December 13, 2024

**Re: Gulf Eagle Supply Site Development Plan – 1455 Selix Grove ((PPR1911, CON203)  
Stormwater Permanent Control Measure – Rain Garden Infiltration Letter  
M.V.E. Project No. 61078**

SPILLWAY DETAIL  
SCALE: NTS

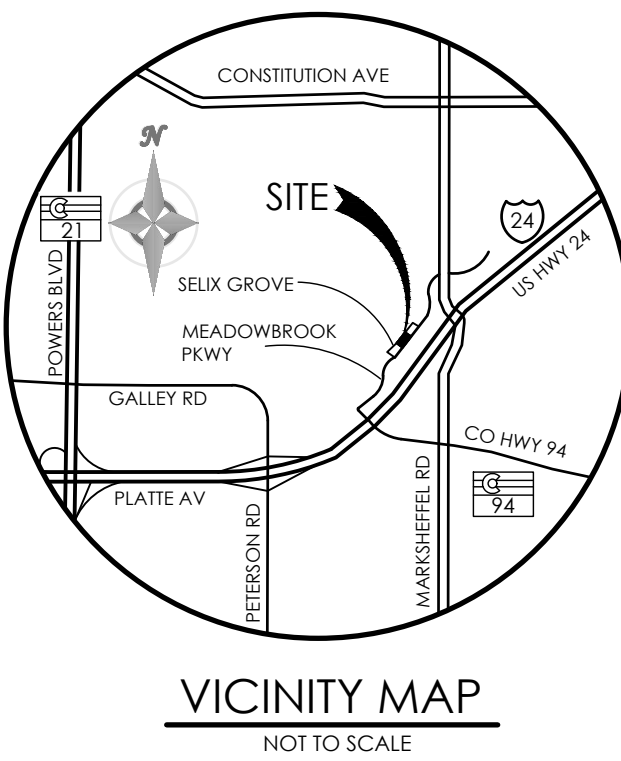
To avoid confusion, remove "outlet structures" since the RGs don't have any. They are full infiltration RGs with spillways.
